These Highways comments are based on additional work done and submitted by the applicant in response to the initial comments of 29/06/23 and appended below.

This application is for the erection of 12 dwellings with parking and an access off Fullwood Drive, a 30mph two-way residential access road of approximately 5.5m width with footways and street lighting present.

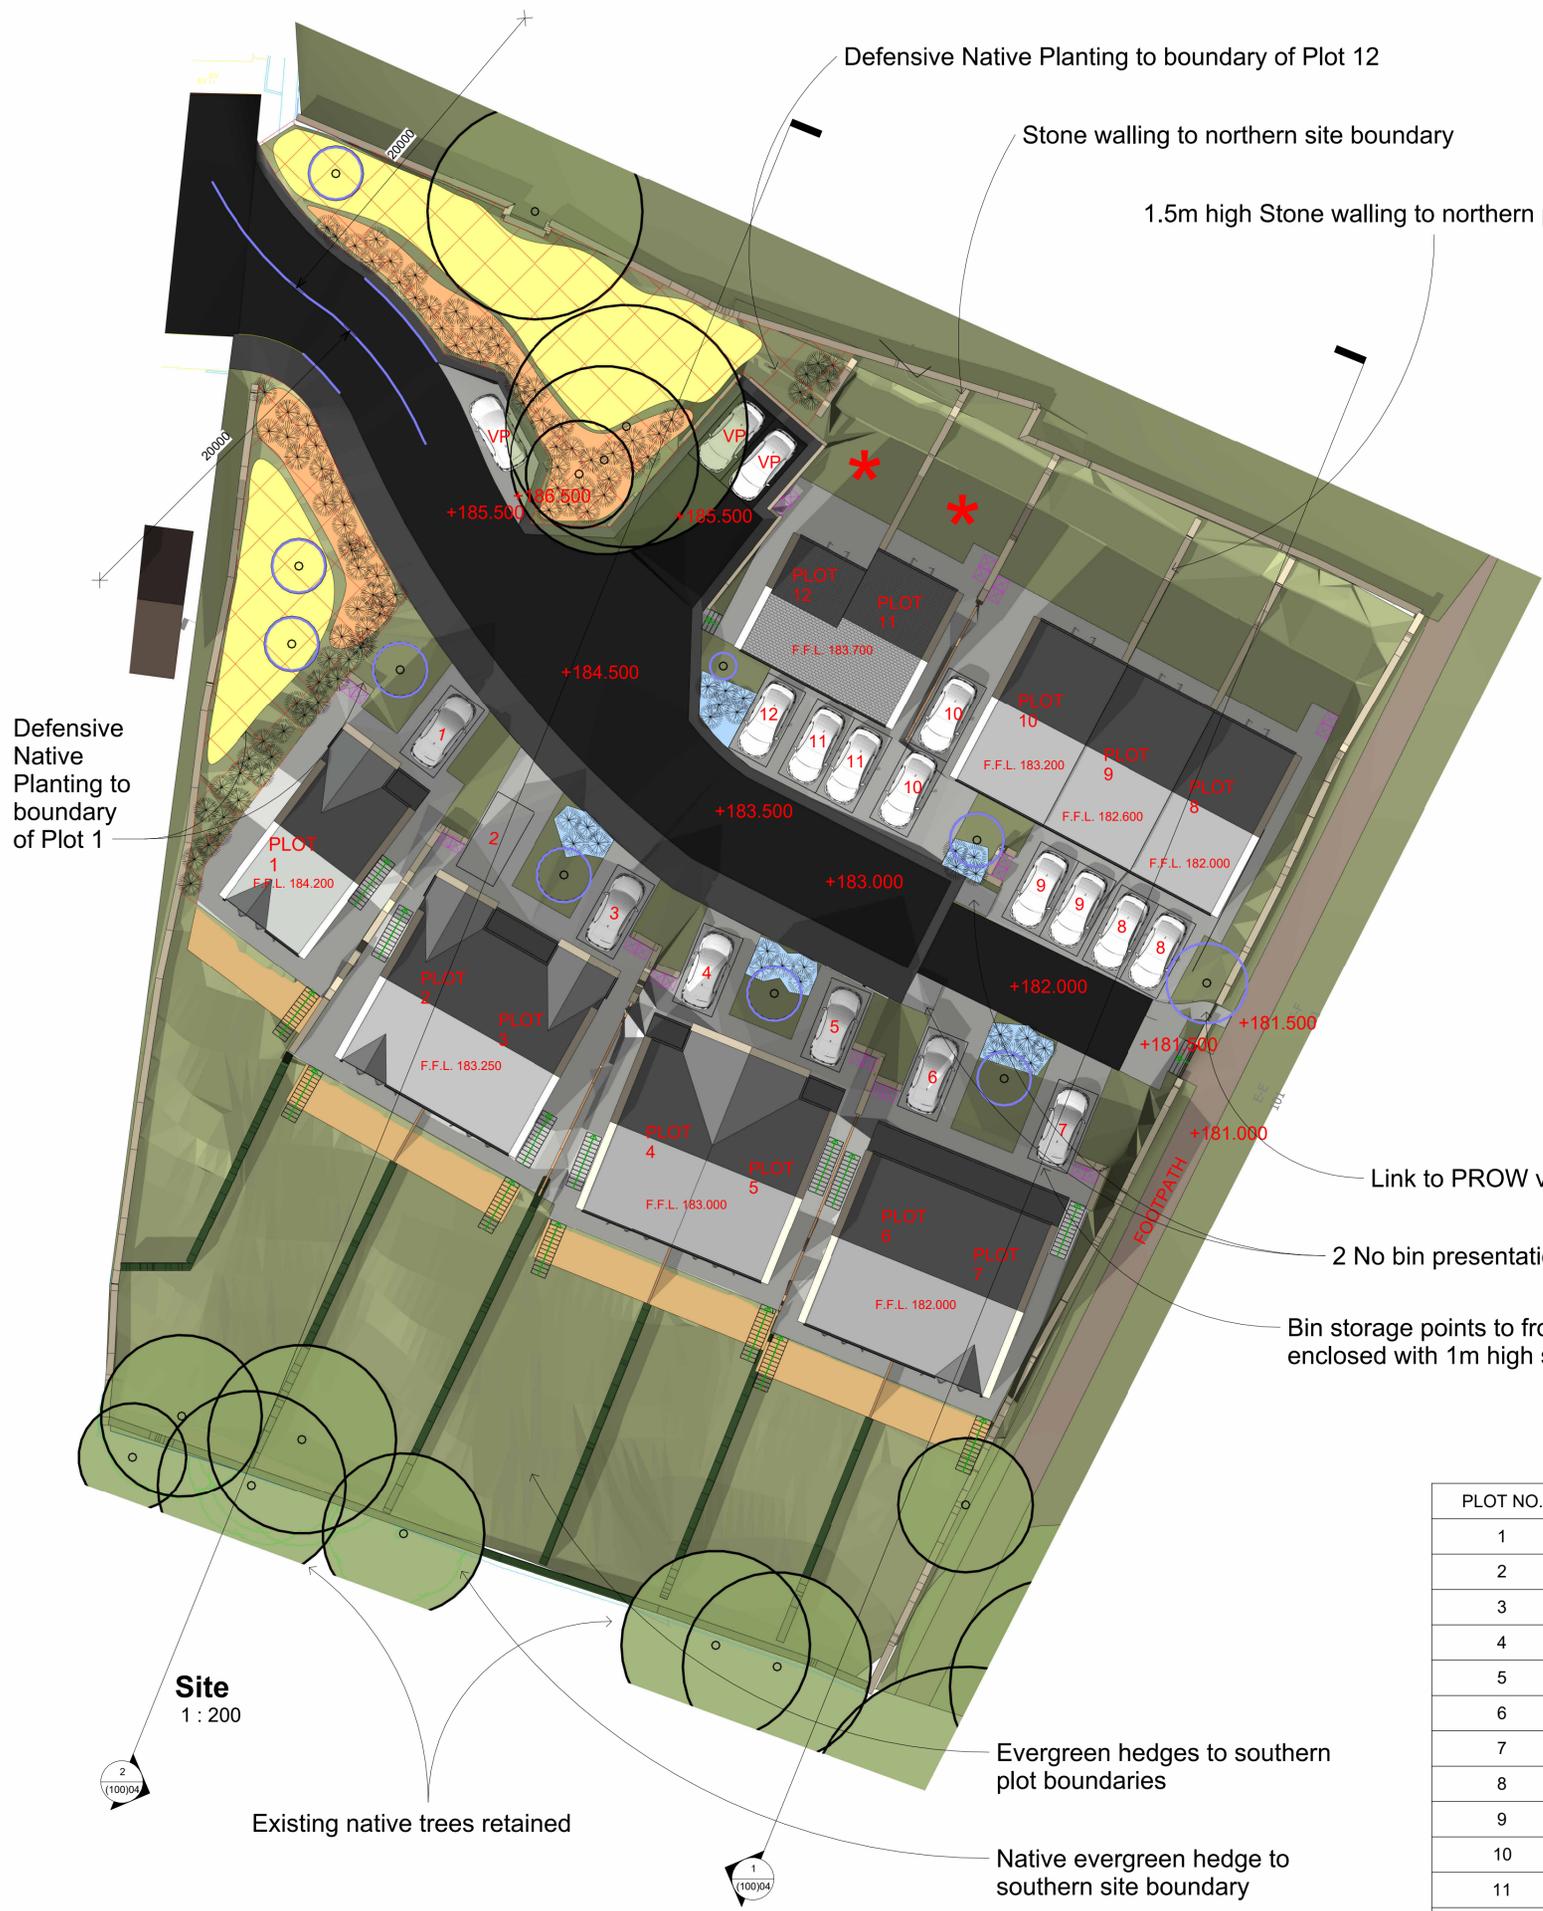
Drawing No (100) 03 Rev I shows an improved access road off the existing turning head and the curve in the road is now designed to match standards with a 20m radius.

Drawing No (100) 03 Rev I shows the parking provision for the proposal site now matches the required local standards, parking provision for plots 11 and 12 has been amended with plot 12 being reduced to a single bed dwelling requiring just the one parking space.

Drawing (100) 03 Rev I shows that there are to be three visitor parking spaces, and this would be acceptable for 12 dwellings.

Drawing No (100)03 Rev I shows the location of waste storage and collection points, and these are generally acceptable (although please note separate consultation comments from the Kirklees Waste Strategy team.

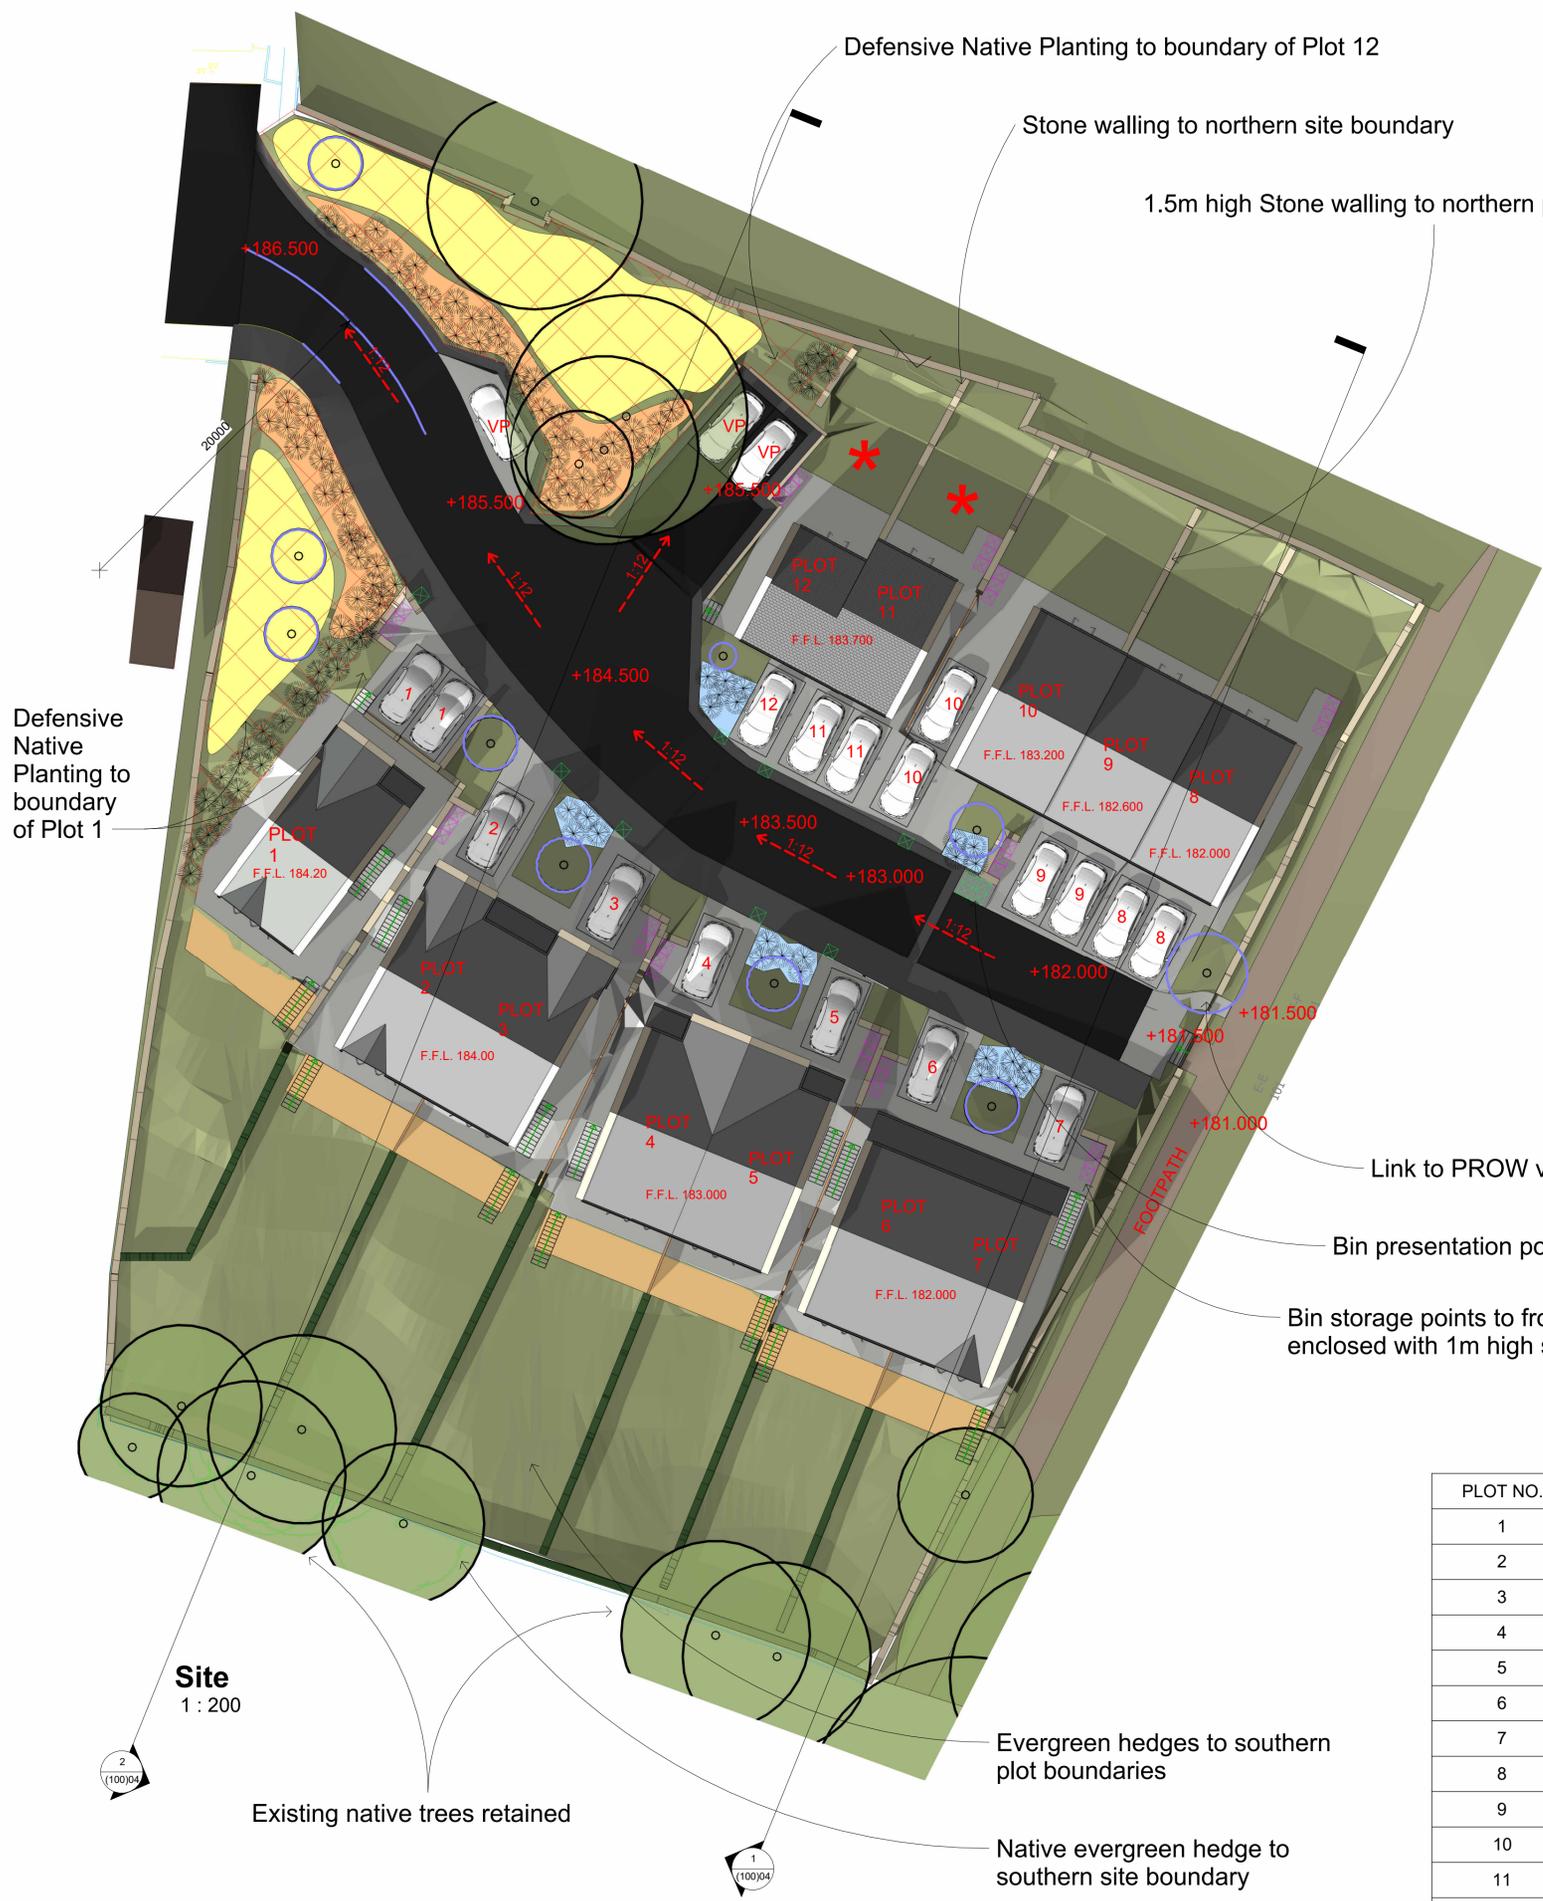
The access road through the site is positioned quite clumsily off the existing turning head and drawing (100)03 Rev E shows it coming off at a dogleg from the existing road, this would be an uncomfortable manoeuvre for larger vehicles such as a refuse truck. We would like to see a smoother transition from the existing highway to the proposed access road. There is also a curve immediately after the junction with the existing turning head and this appears to have a centreline radius greater than that requested in local guidance. It may be desirable to amend the layout of the highway to create a better transition and reduce the initial centre line radius of the first curve. Either way the transition and the access road should be shown to be able to take an 11.22m refuse truck by means of a swept path analysis.

Based on details contained in drawing No (100)03 Rev E and drawing (100)16, the proposals do not appear to adhere to local guidance relating to parking provision especially relating to plots 11 and 12 which appears to have only 1 parking space. The concern is that these dwellings may decide to use the adjacent visitor parking spaces and that would reduce the availability of parking.

Drawing No (100)03 Rev E shows the location of waste storage and collection points, and these are generally acceptable (although please note separate consultation comments from the Kirklees Waste Strategy team), however this would depend on the locations being accessible to a Kirklees refuse truck and this would require submission of the swept path analysis.
